Subject: New Request for Advice - Lane Cove North Design development changes (SSD-71687208-Mod-2)

Thank you for your referral received 2 June 2026 requesting advice from the Marine Coast Estuary and Flood Team (Greater Sydney). The referral provided a response from the Applicant to flooding concerns raised by CPHR in the letter dated 8 May 2026.

CPHR have reviewed the following documents to determine if they have addressed matters raised in our advice dated 15th May 2026.

Overland Flow Path Sections

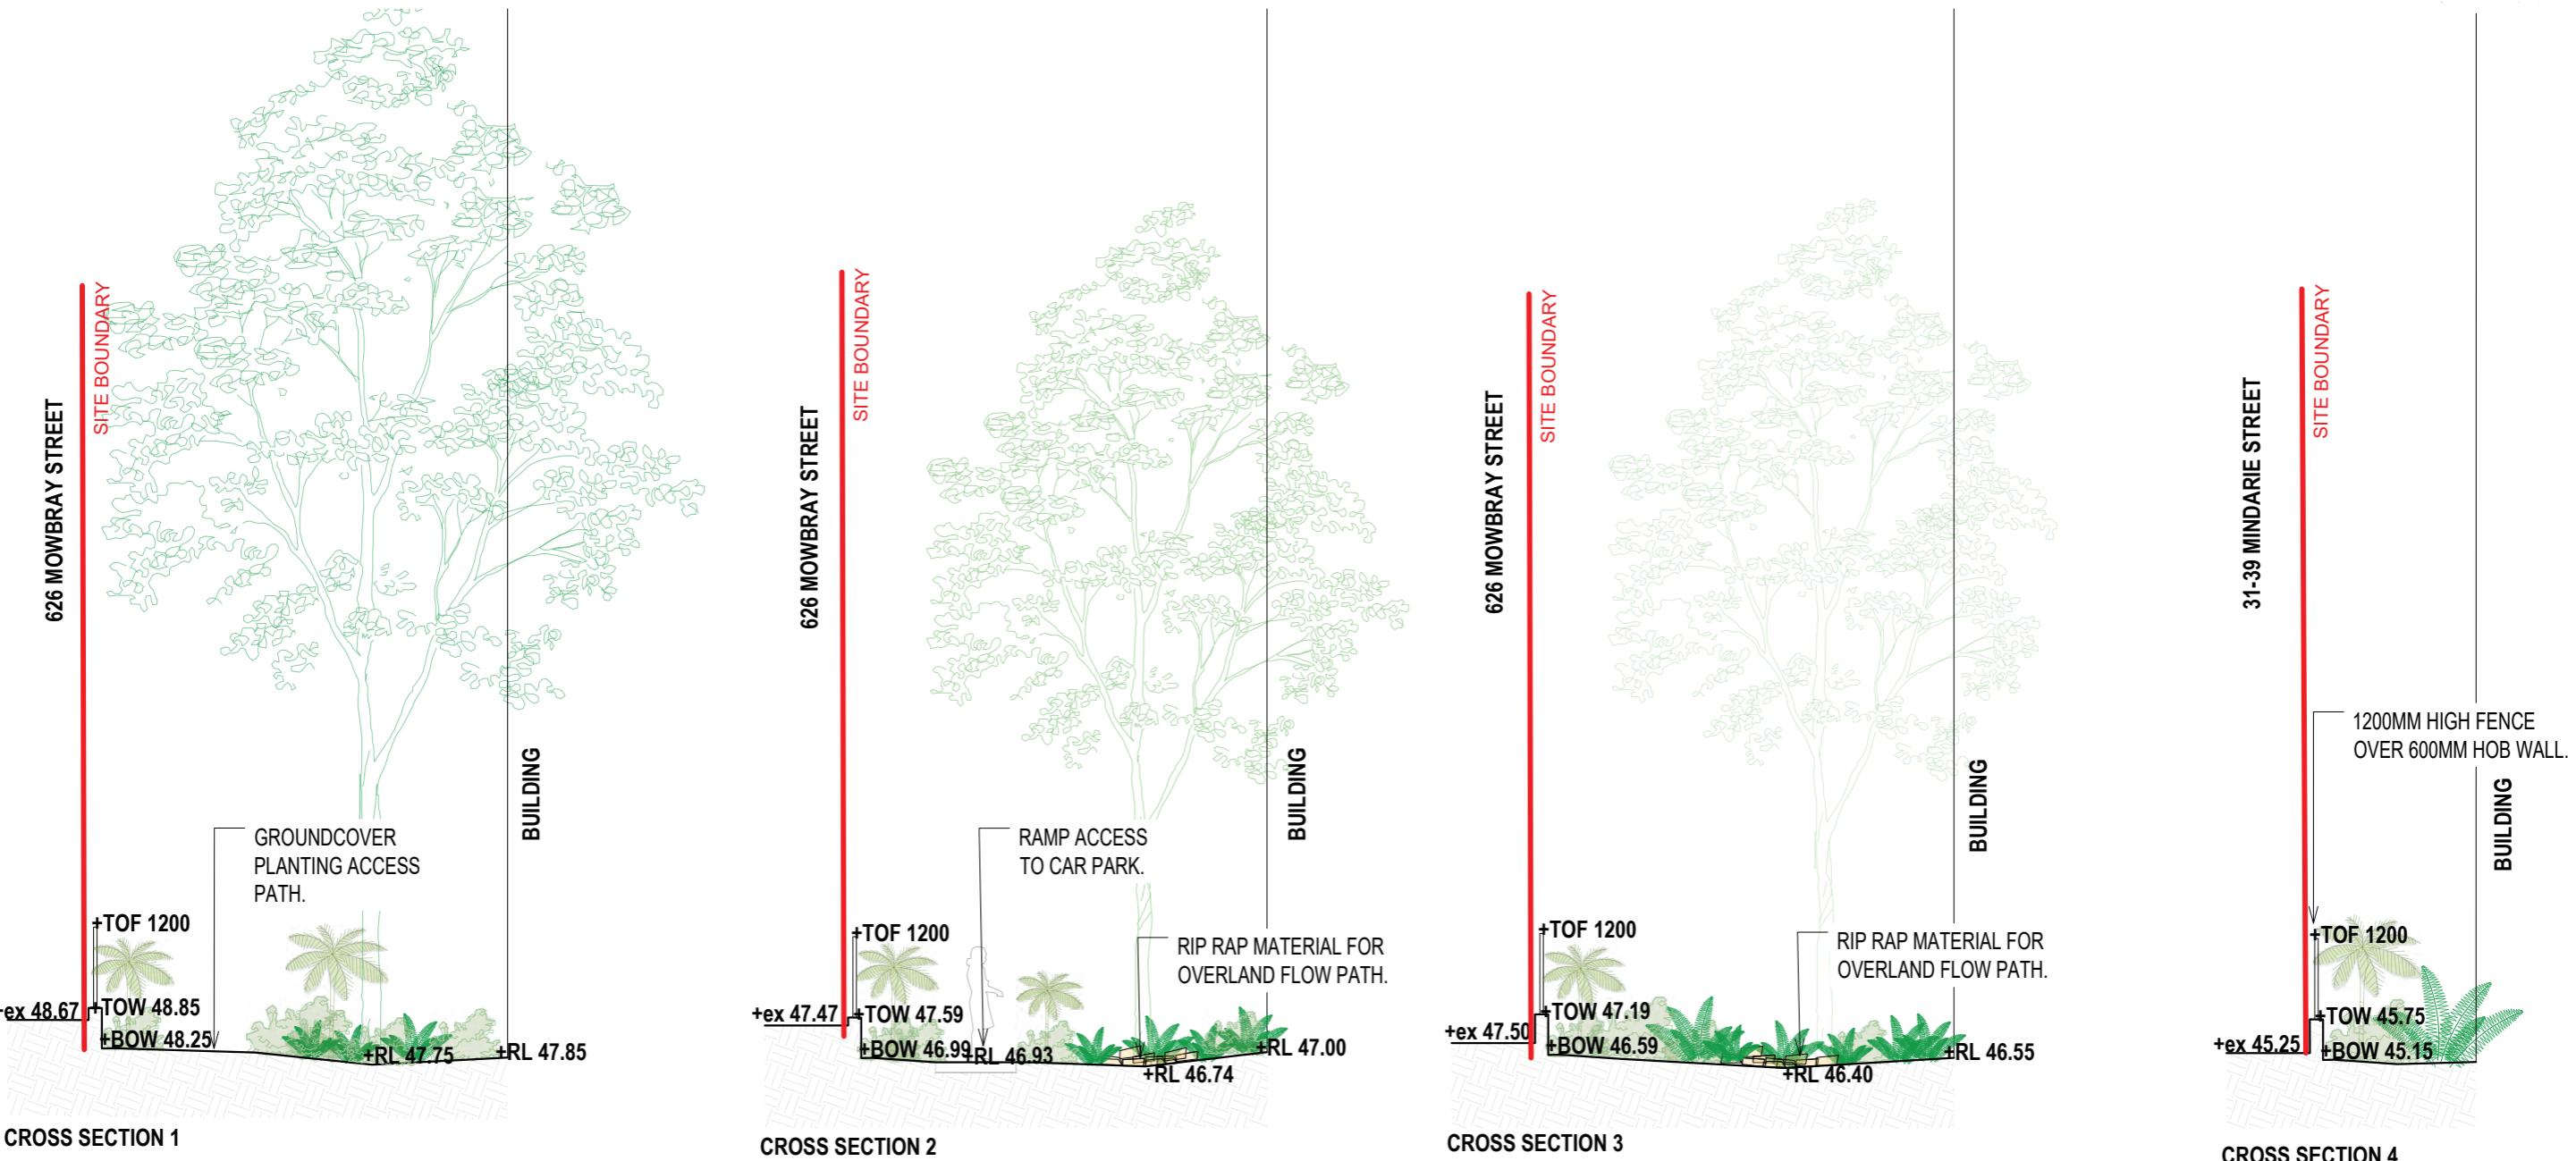
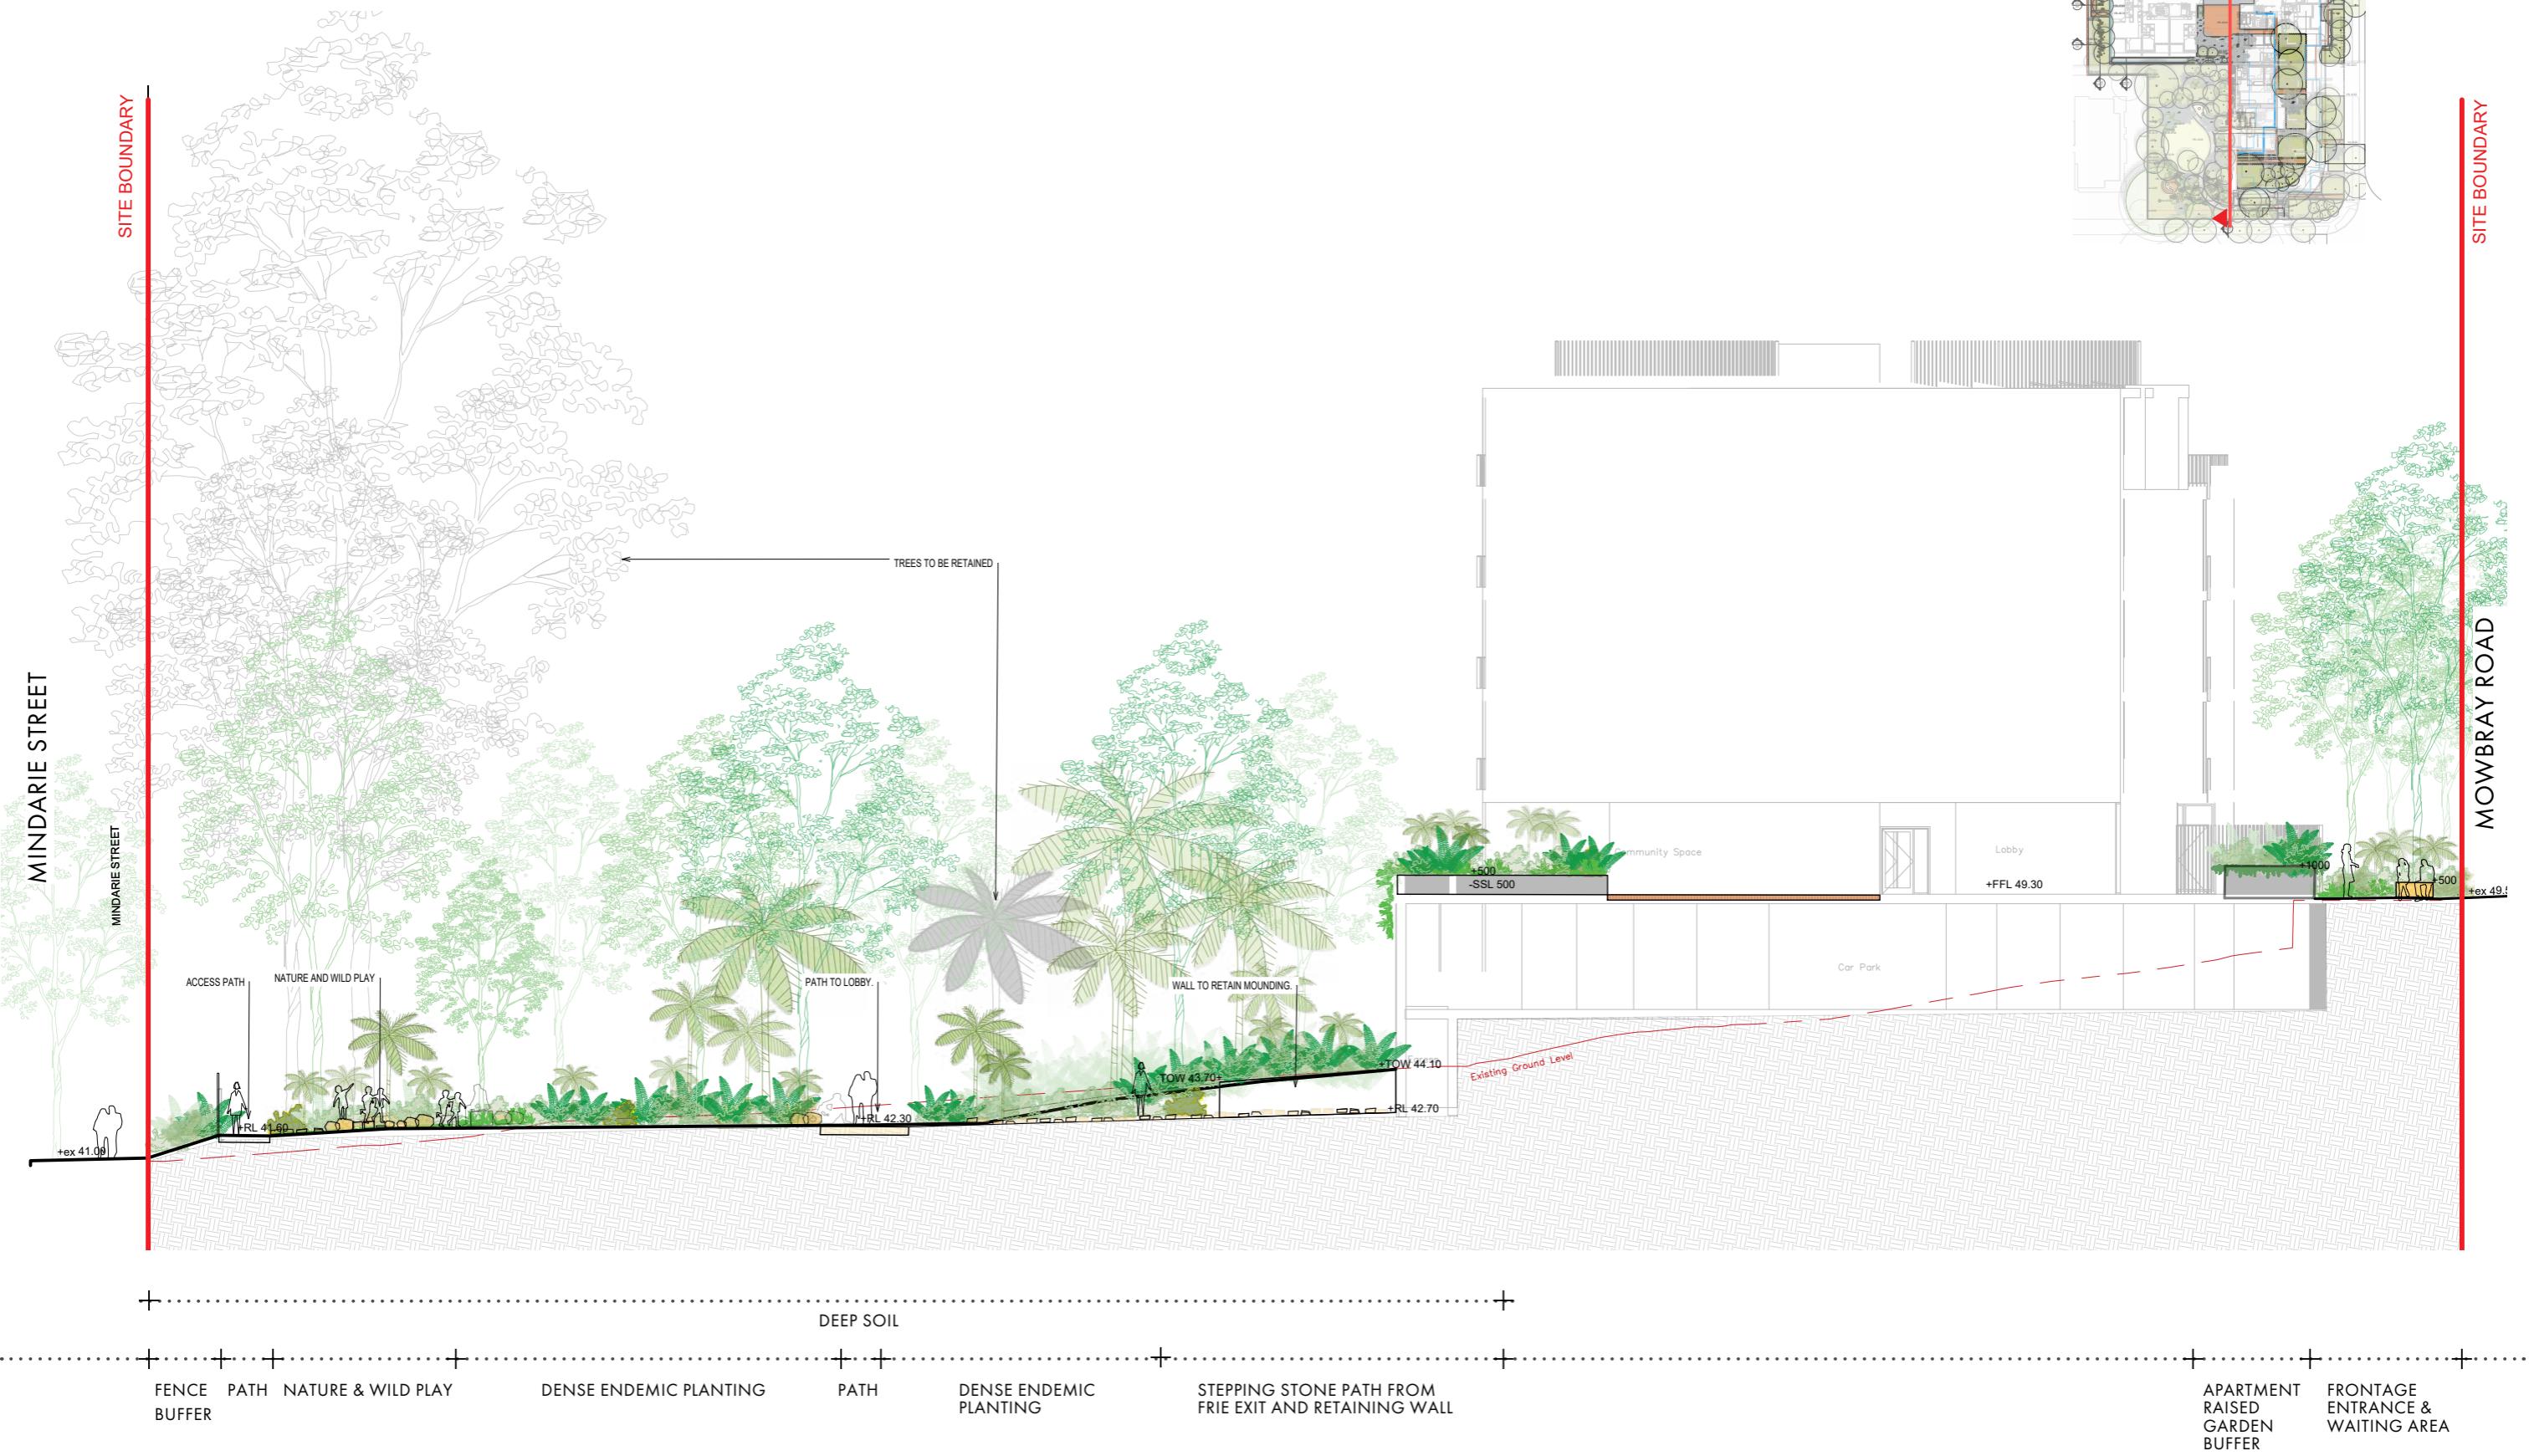
The Stormwater comparison refers to requests made by Lane Cove Council. It is noted that the plan shows significant tree planting along the overland flow path and above the proposed stormwater pipe alignment. Lane Cove Council officers should confirm that this arrangement is acceptable from a maintenance perspective.

Detailed design of pipework diversions and the overland flow path should ensure that the system is maintainable and has sufficient capacity to safely convey the flows modelled in the FIRA by WSP.
